**DELEGATED DECISION FOR APPLICATION FOR CERTIFICATE OF
LAWFUL DEVELOPMENT**

Reference no.: 2024/CL/92356/E

Site: 43, Windmill Hill Lane, Emley Moor, Huddersfield,
HD8 9TA

Description: Certificate of lawfulness for proposed erection of
side and rear extensions, front porch and outbuilding

PROJECT	Alterations to 43 Windmill Hill Lane Emley Moor, Huddersfield HD8 9TA		
CLIENT	A & S Harding		
SUBJECT	Proposed Plans Outbuilding - PD		
SCALE	1:50 @ A1	DRAWN	SB
DATE	14/08/2024	DRAWING NO.	23-003-1G
		REV.	-

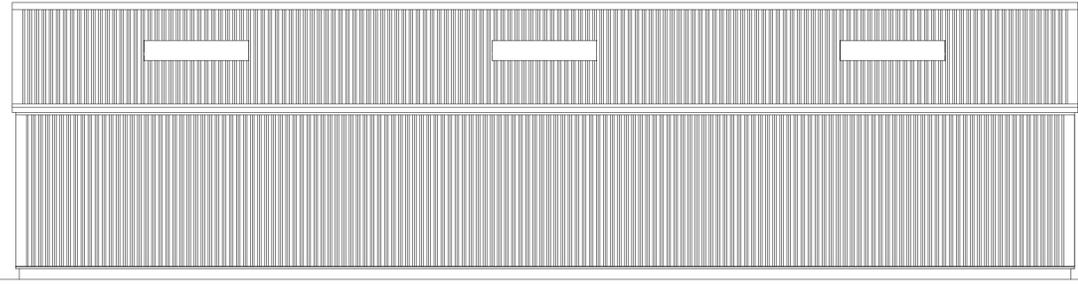
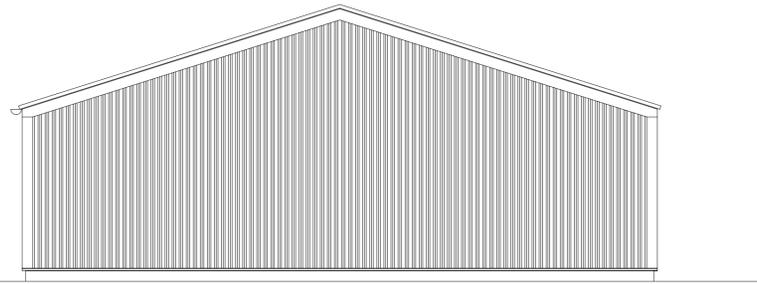
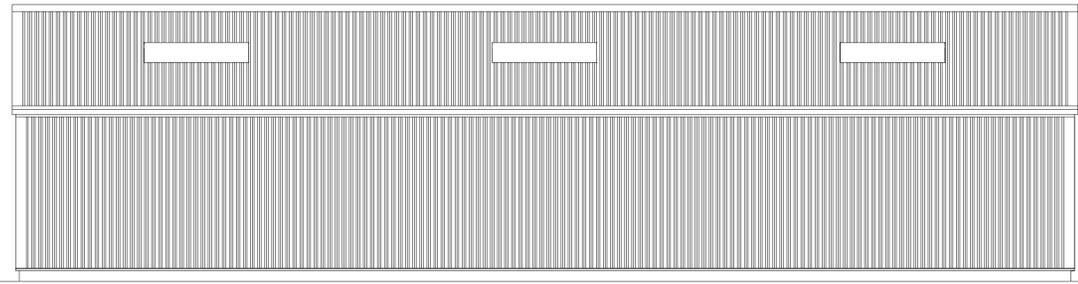
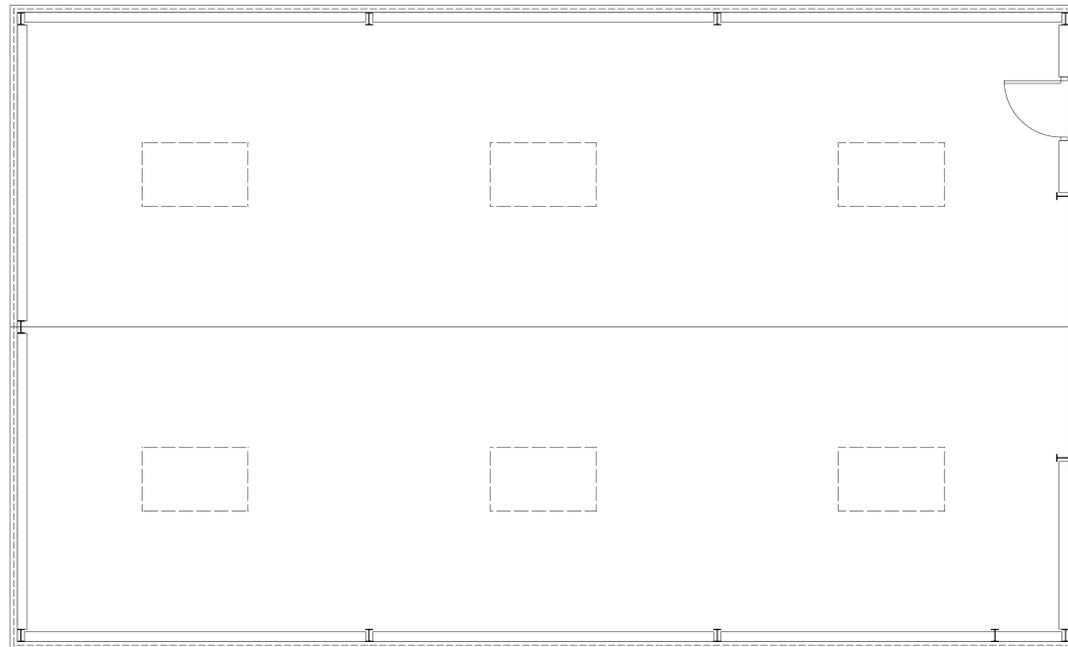
The outbuilding shall be for domestic use. The outbuilding is more than 2m from any boundary with eaves height of 2.5m & ridge height of 4m. No more than 50% of curtilage would be covered by buildings.

Comment: *The proposed outbuilding is to the rear of the property.*

Comment: *The outbuilding would not be located within 2 metres of the boundary of curtilage. The dual-pitched roof of the outbuilding would have a height of 4 metres.*

Comment: *The structure would have an eaves height of 2.5m.*

Comment: *The proposed outbuilding would be for domestic use – classic car storage.*

PROJECT		Alterations to 43 Windmill Hill Lane Emley Moor, Huddersfield HD8 9TA		
CLIENT		A & S Harding		
SUBJECT		Proposed Plans - PD		
SCALE	1:50 @ A1	DRAWN	DRAWING NO.	REV.
DATE	14/08/2024	SB	23-003-1G	-

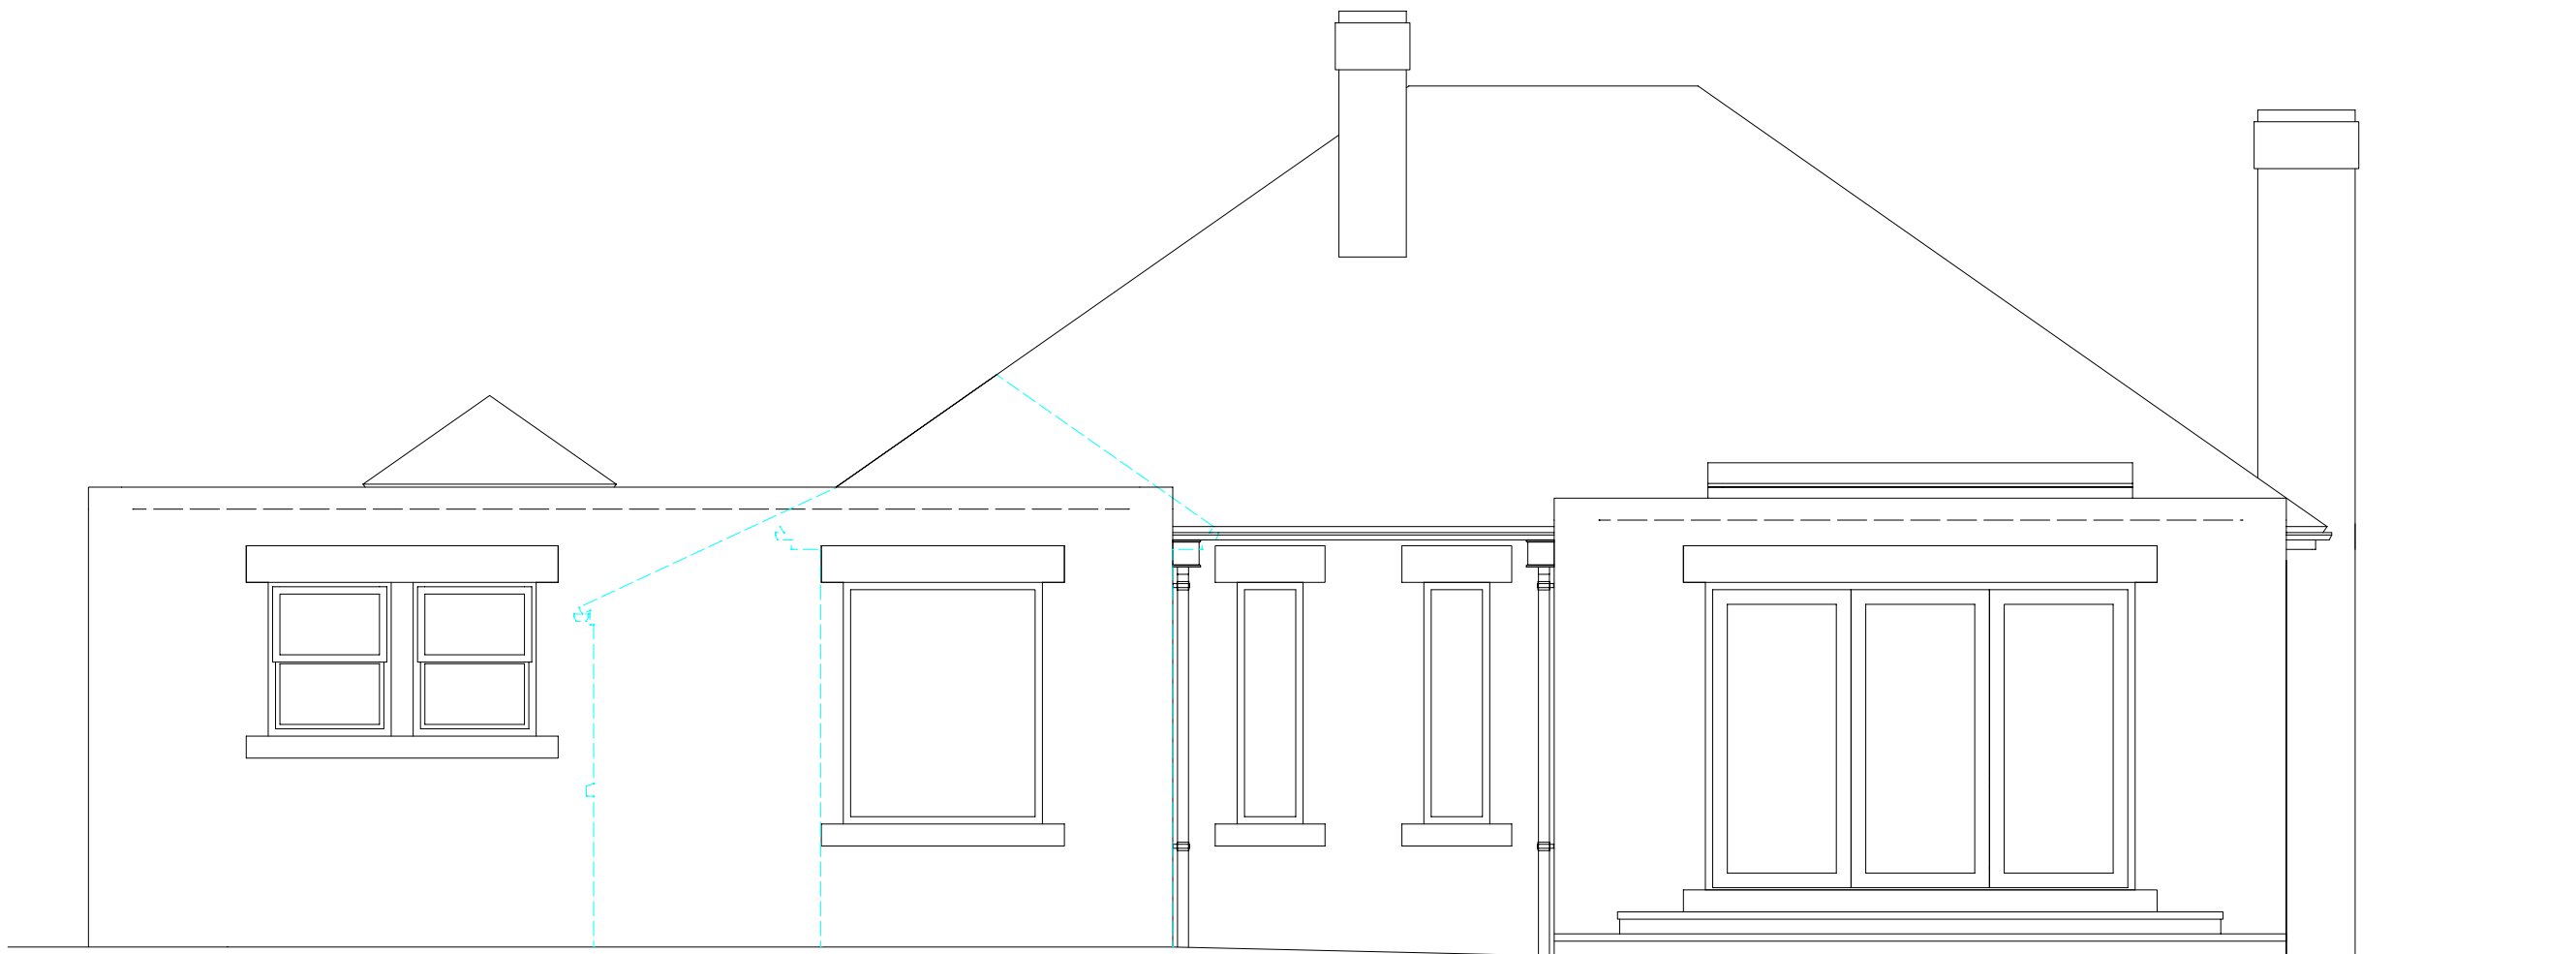
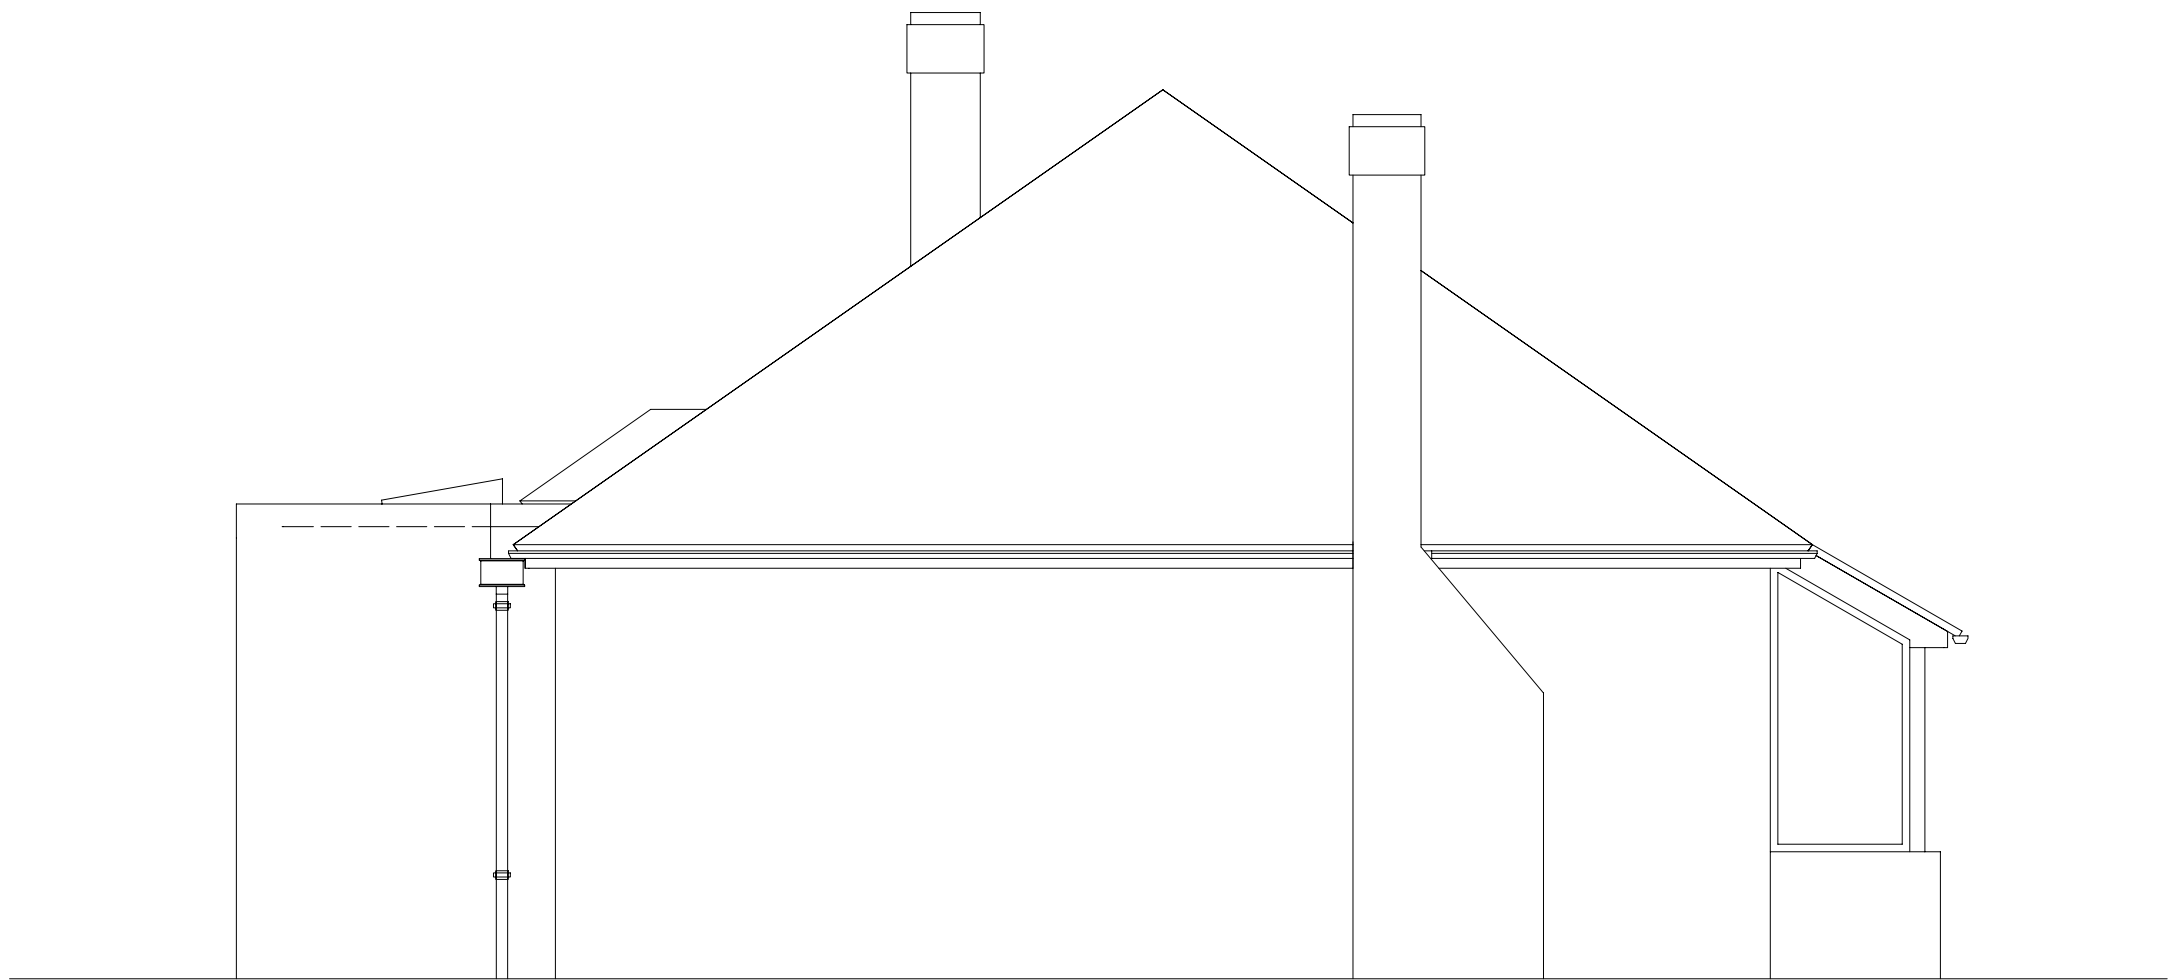
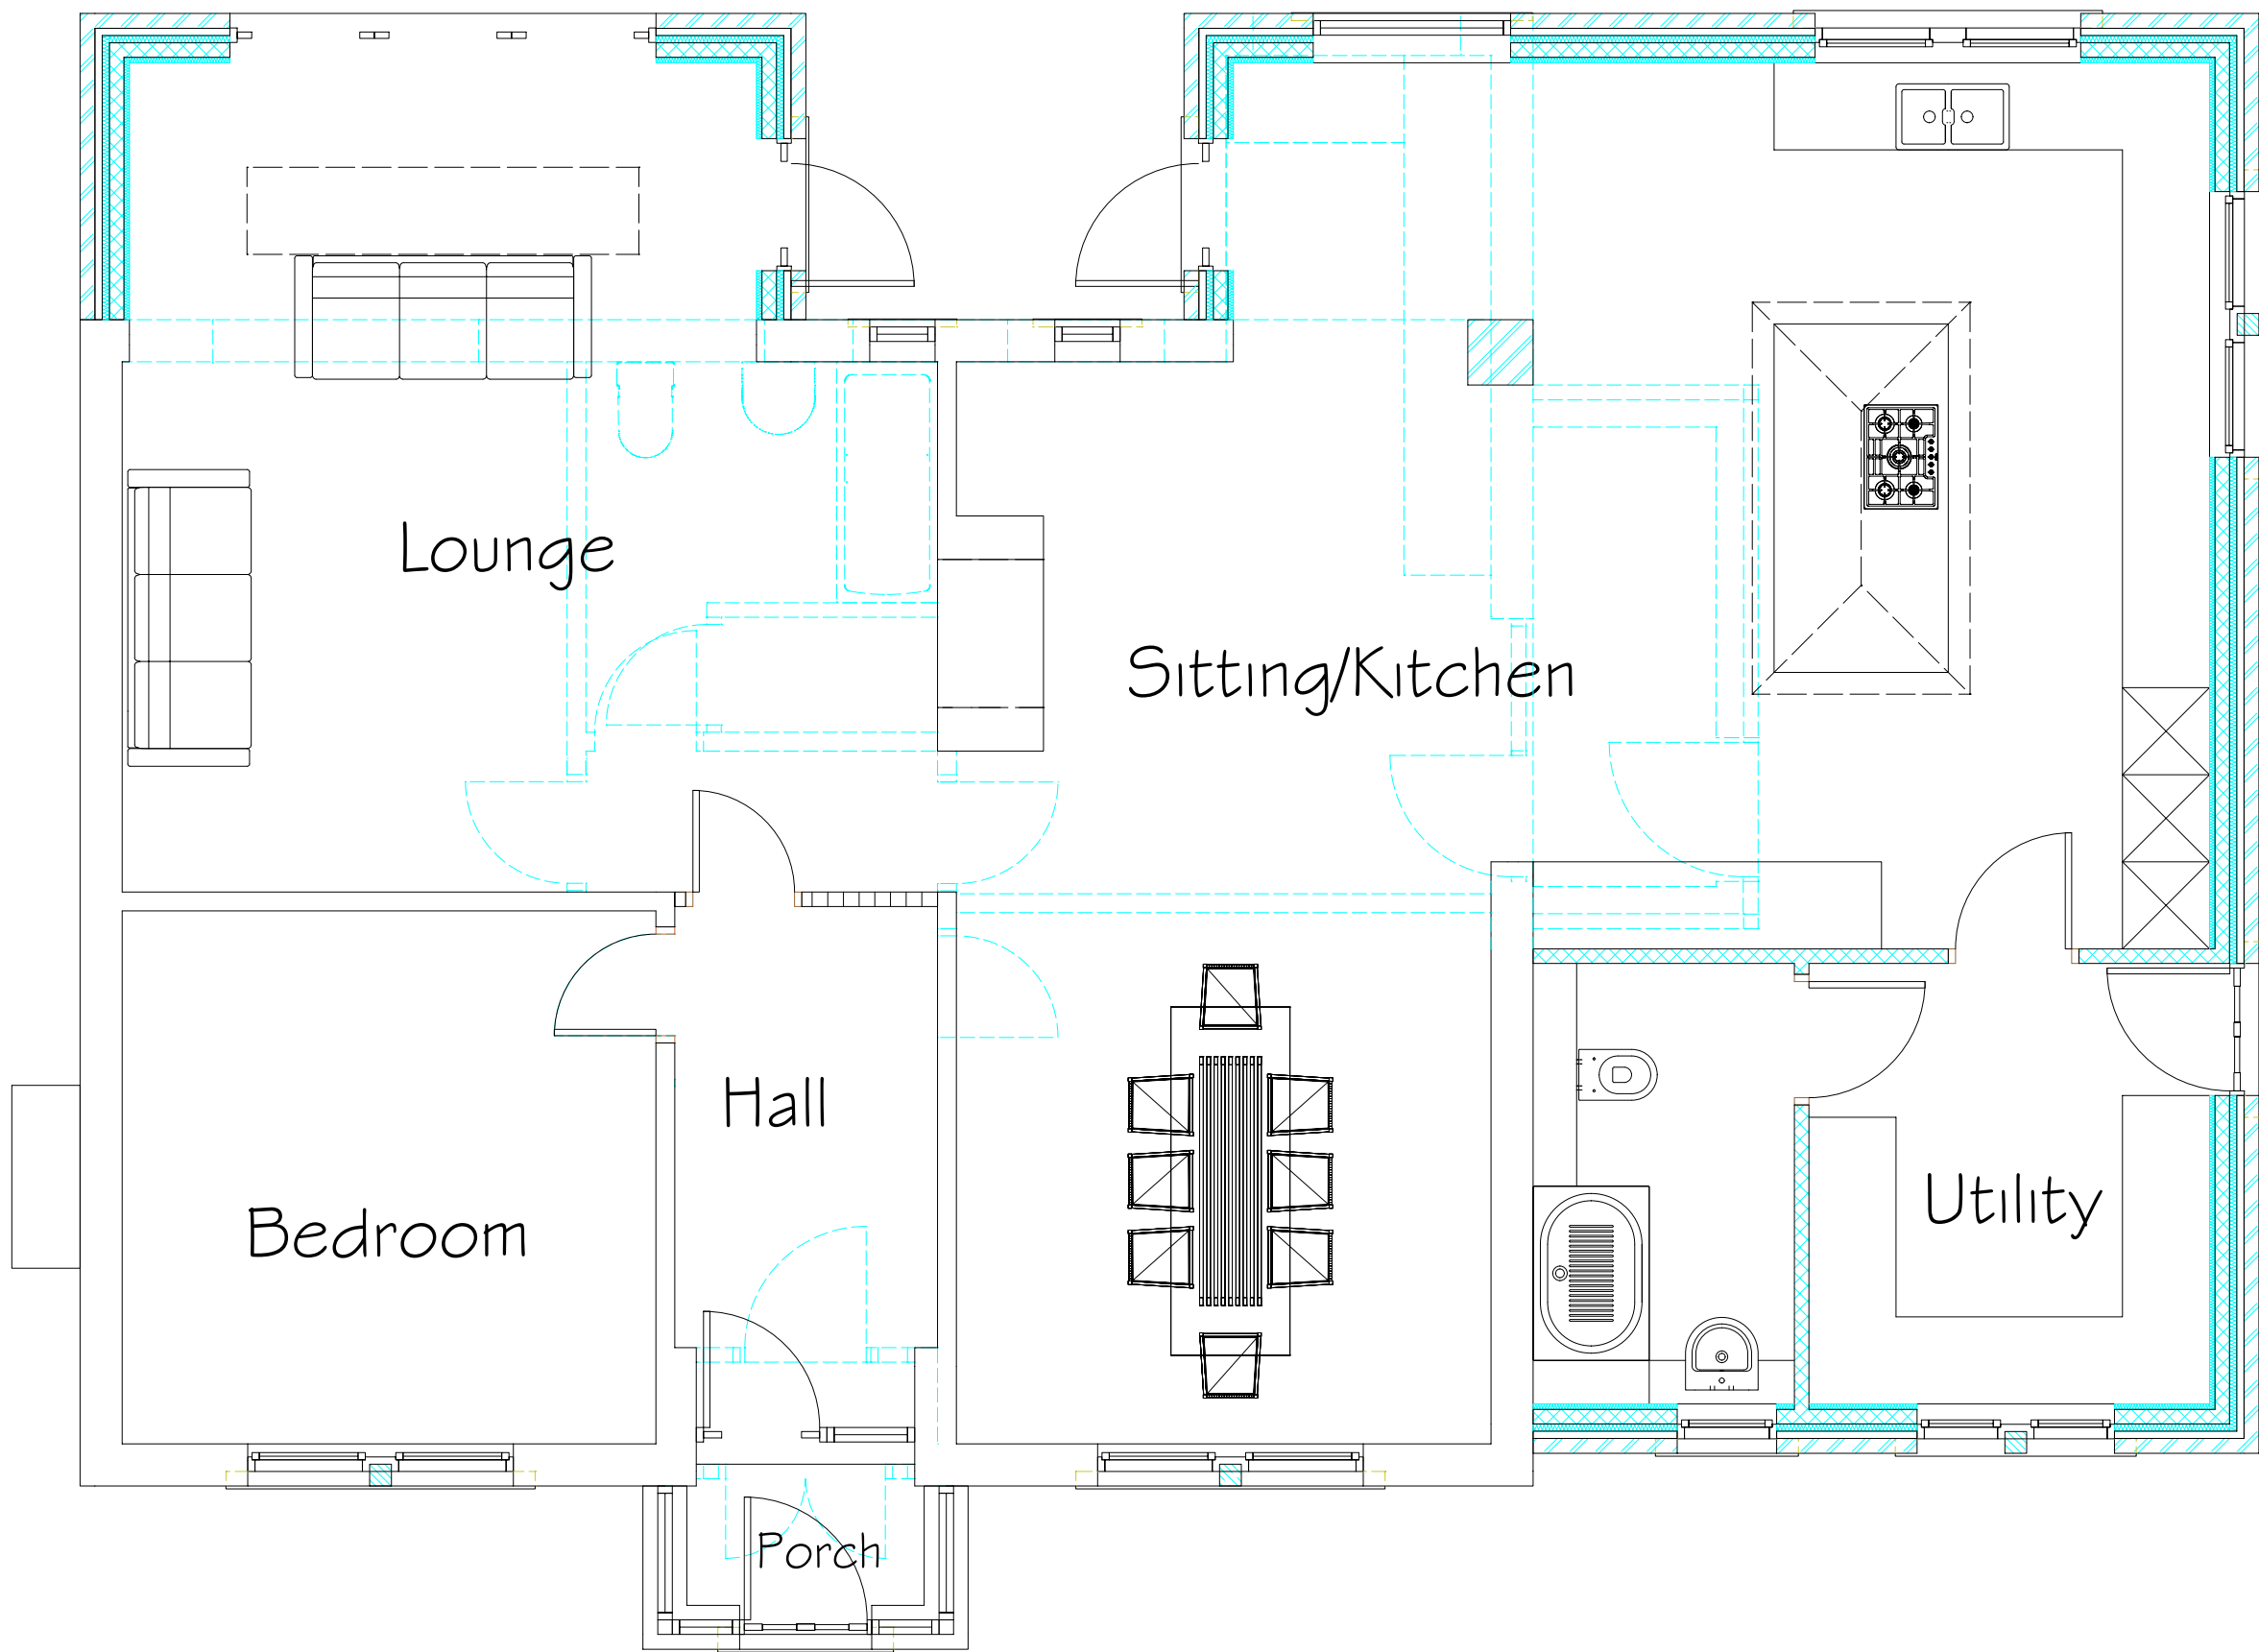
The rear extension would project from the rear elevation of the property by 2.1m and would be a total width of 5m with an eave's height of 3.0 m to a flat roof.

The side extension would project from the existing dwelling by 5m and would be a total width of 7.4m with an eave's height of 3.0m to a flat roof.

The porch shall extend from the front elevation by 1.1m with a width of 2.2m, with an eave's height of 2.4m and an overall height of 2.9m to the ridge of the pitched roof.

Comment: *The height of the enlargement would not exceed the highest part of the roof of the existing dwellinghouse.*

Comment: *The height of the eaves of the part of the dwellinghouse enlarged shall not exceed that of the original dwelling.*

Comment: *The enlarged parts of the dwellinghouse would not extend beyond a wall forming part of the principal elevation. While there is a public footpath to the north east of the site it is separated by 40 metres and an area of woodland thus the side extension is not considered to front a highway.*

Comment: *The proposal would be single storey in scale. The rear elevation would not extend more than 4m from the original dwellinghouse and the rear enlargement does not exceed 4 metres in height.*

Comment: *The enlarged part of the dwellinghouse would not be within 2m of the boundary. The eaves would not exceed 3m.*

Comment: *The side extension projects from the side elevation of the original dwellinghouse including the side of an original rearward projection. While the original rearward projection is not retained, the proposed wrap-around to the rear elevation does not enlarge the original dwellinghouse at this point and as such the enlarged part projects beyond the side elevation or the original dwellinghouse by 5 metres and therefore would not have a width greater than half the width of the dwellinghouse. The enlargement is single storey and less than 4 metres in height.*
